**WEST SUSSEX COUNTY COUNCIL
PLANNING SERVICES CONSULTATION**

SUBJECT: FG/115/17/PL - 4 No. bungalows.

Amendment received.

44, Ferringham Lane, Ferring, West Sussex, BN12 5LU

Site layout block plan

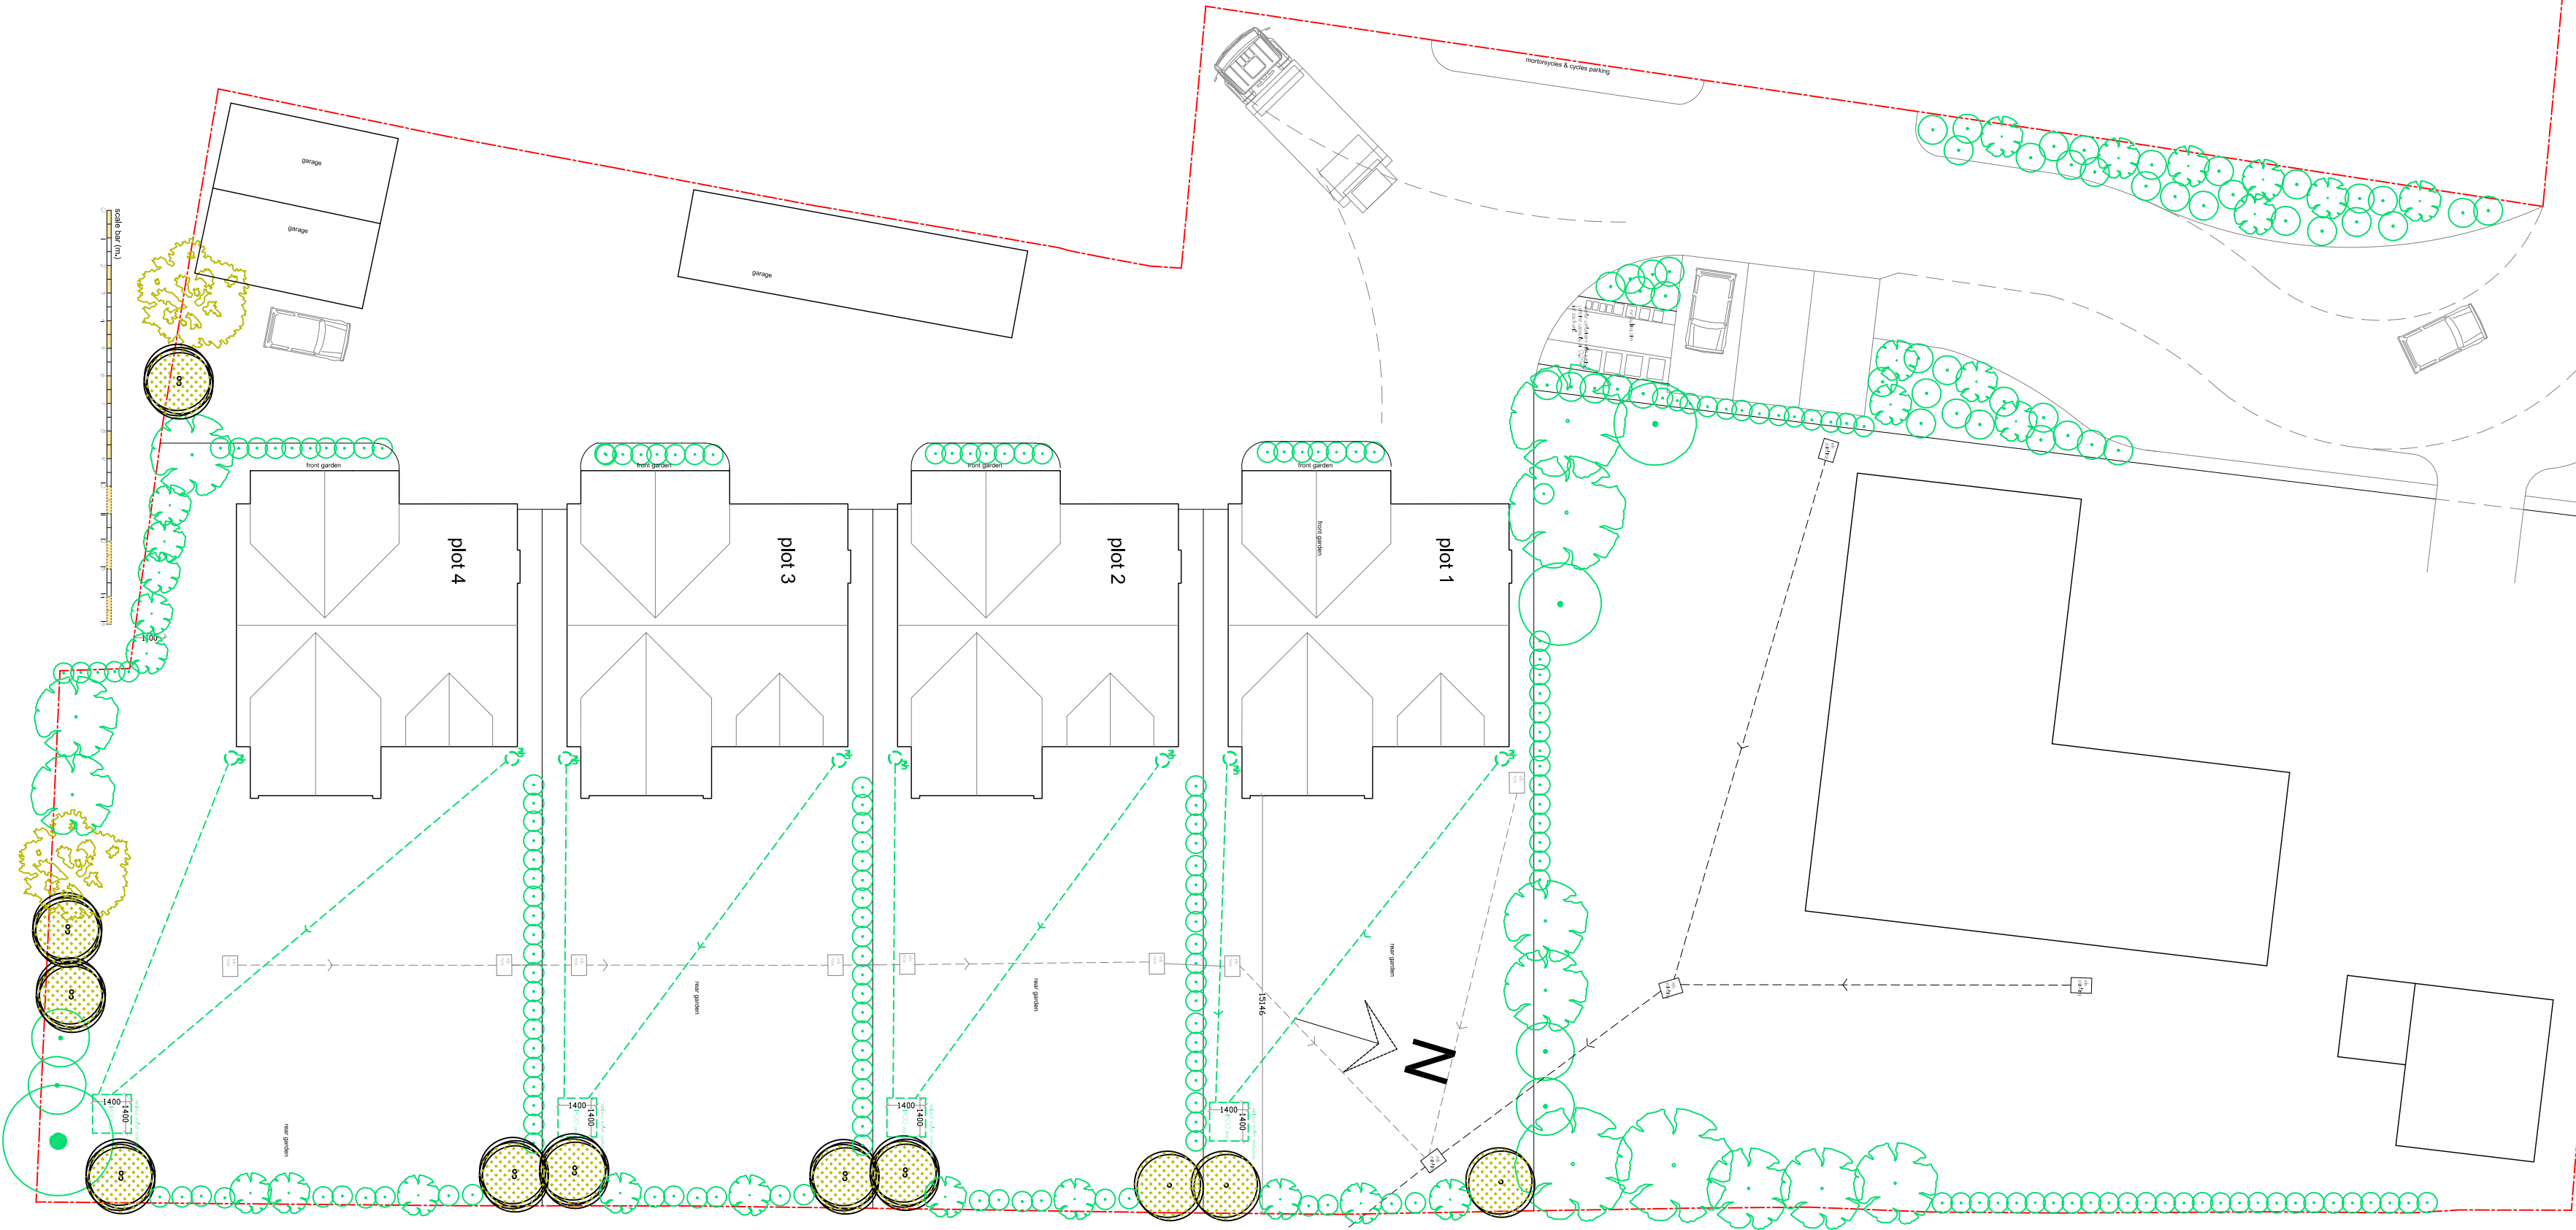
Upon review of these plans the garages have been increased in size to 3 x 6 metres and the dwellings have been repositions further west within in the site.

The garages are now considered to be adequately sized.

The repositioning of the dwelling has resulted in the area of hardstanding parking spaces allocated to each dwelling reduced. Hardstanding parking will now take place in the form of 1 space per dwellings provided in parallel fronting the dwellings.

Typically parallel hardstanding spaces should measure 6.0 metres in length to allow for manoeuvring room into and out of the space. The demonstrated spaces do not meet this guidance and the provision of spaces as shown does seem to restrict access to the dwellings front doors and side access points. The workability of the parking spaces would not be considered a matter for the Local Highway Authority though I can confirm that the provision of each dwelling with a garage and hardstanding space (+ shared visitor spaces) would be considered adequate to meet the demand of the development.

The repositioning of the dwellings may impact the ability for larger vehicles (Fire and Refuse) to turn on site. Swept path tracking plans should be provided to demonstrate that the ability for larger vehicles to turn on site has been retained. This turning area should not use any area allocated for resident parking.
